Ref 4300

22/8/23

The Beachwalk Retreat - structural assessment of leaning wall.

Proposed Front (SW) Elevation

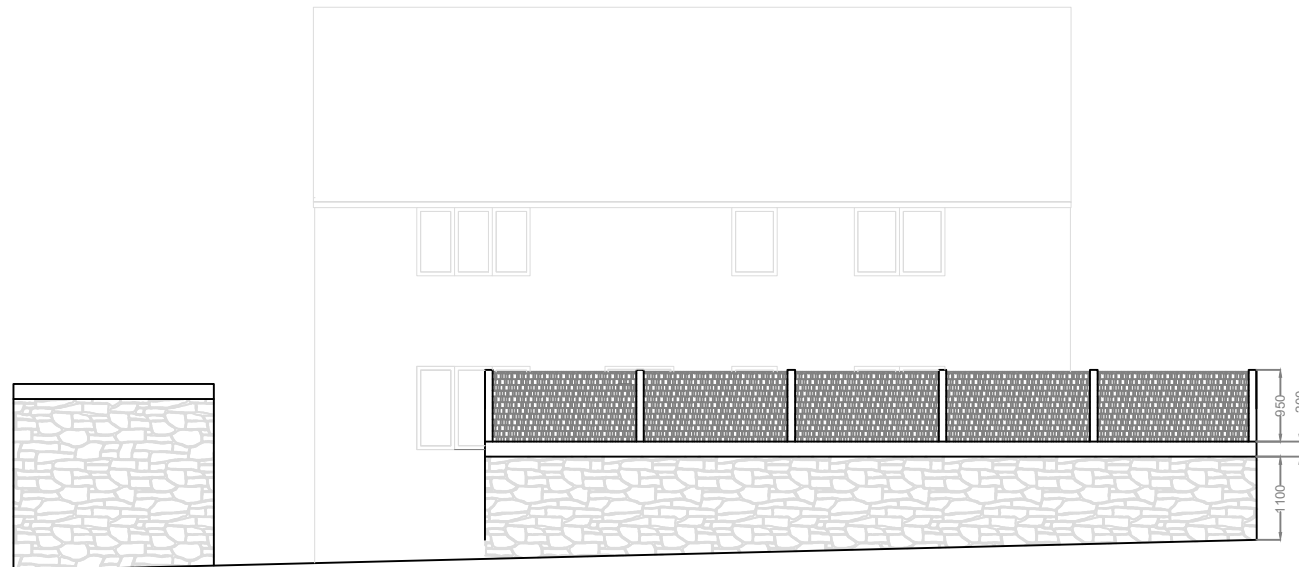
Re your suggestion to remove an upper portion of the wall, this is certainly a possibility if allowed by Planning.

The highest the wall could be at its current angle of lean to maintain an adequate factor of safety, including wind loading, is 1.1 metres. This is also the standard height for pedestrian balustrading.

There would not be scope for adding any kind of solid barrier above this such as a close boarded fence because of the additional wind loading, but a wind-permeable structure could be used. The wall should also be re-pointed and sealed at its base to prevent water ingress to the wall itself and its foundations since weakening of the ground under the base of the wall from water penetration appears to be the original cause of the movement.
